## KITTTITAS COUNTY COMMUNITY DEVELOPMENT SERVICES

August 25, 2009

### **RE: Grove Short Plat (SP-09-00001)**

GROVE SHORT PLAT

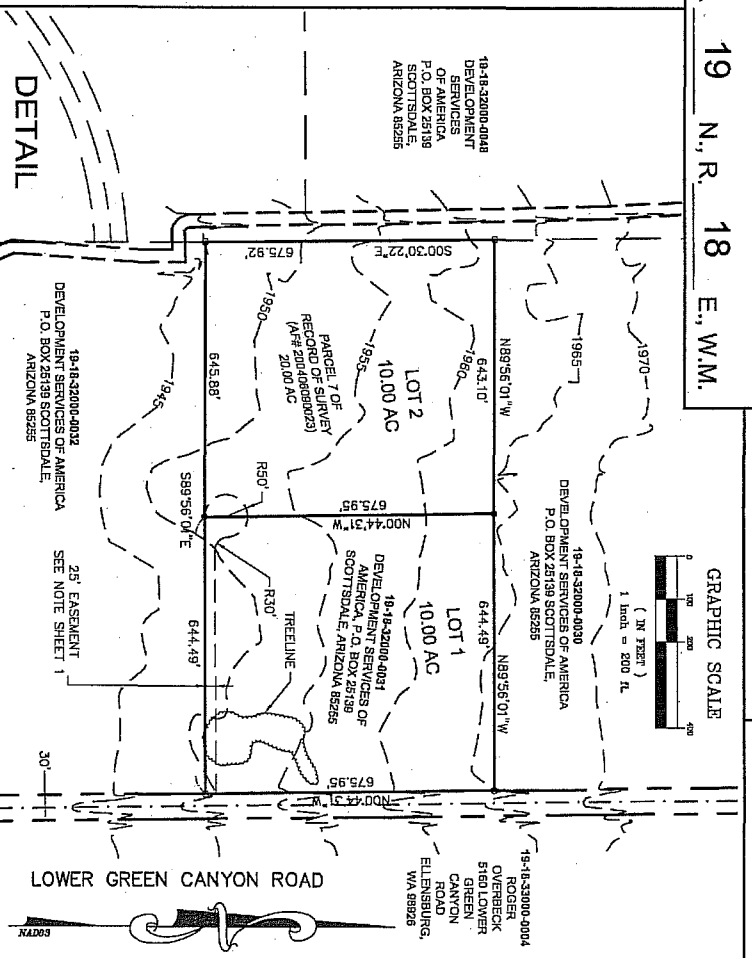
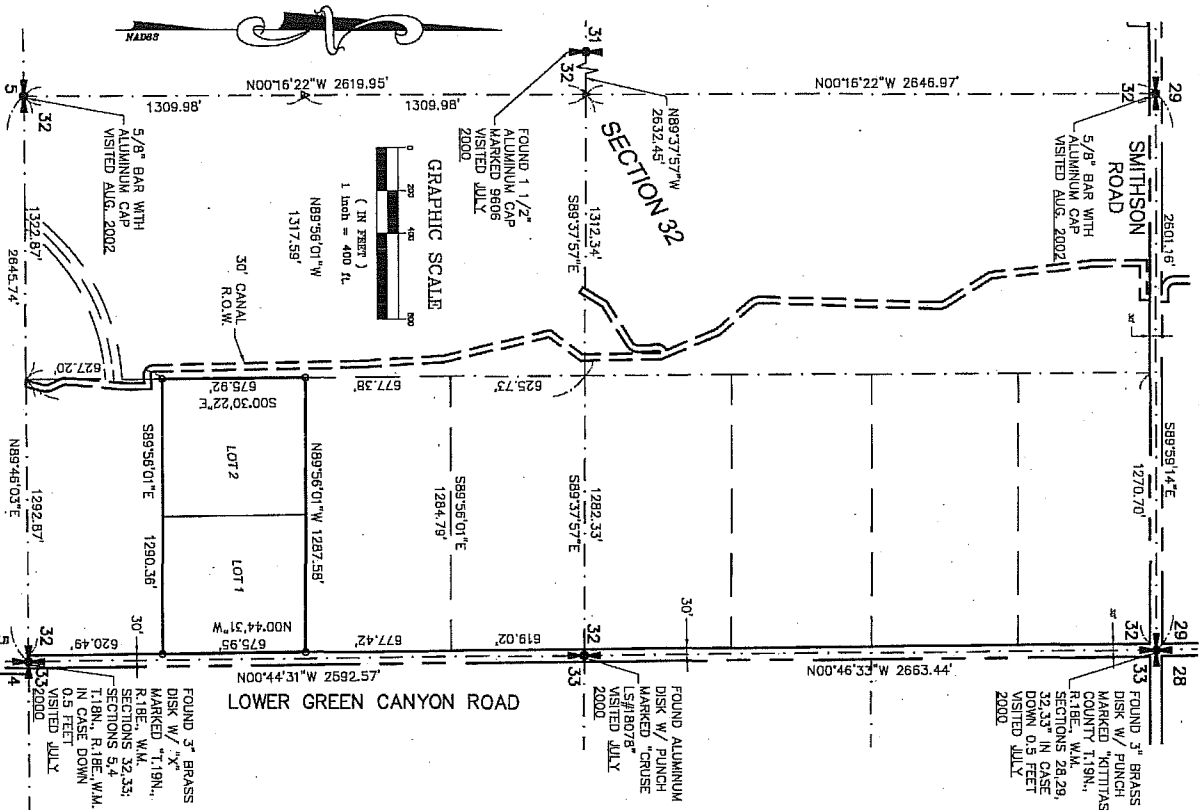
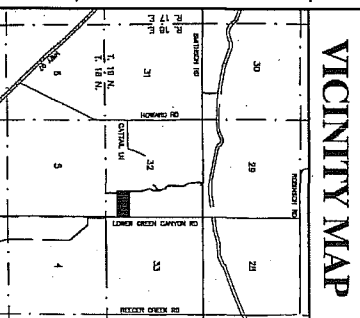
1. Both sheets of the final mylars shall reflect short plat number SP-09-00001 and an accurate legal description shall be shown on the face of the final plat.

8. Both lots of the Grove Short Plat have a PEMC wetland on the property. The Final mylars shall reflect the location of this wetland and a statement on the plat shall read as follows: "Future development of lots may require a study by a certified wetland biologist to determine wetland classification and for buffer requirements pursuant to KCC Critical Areas Code."
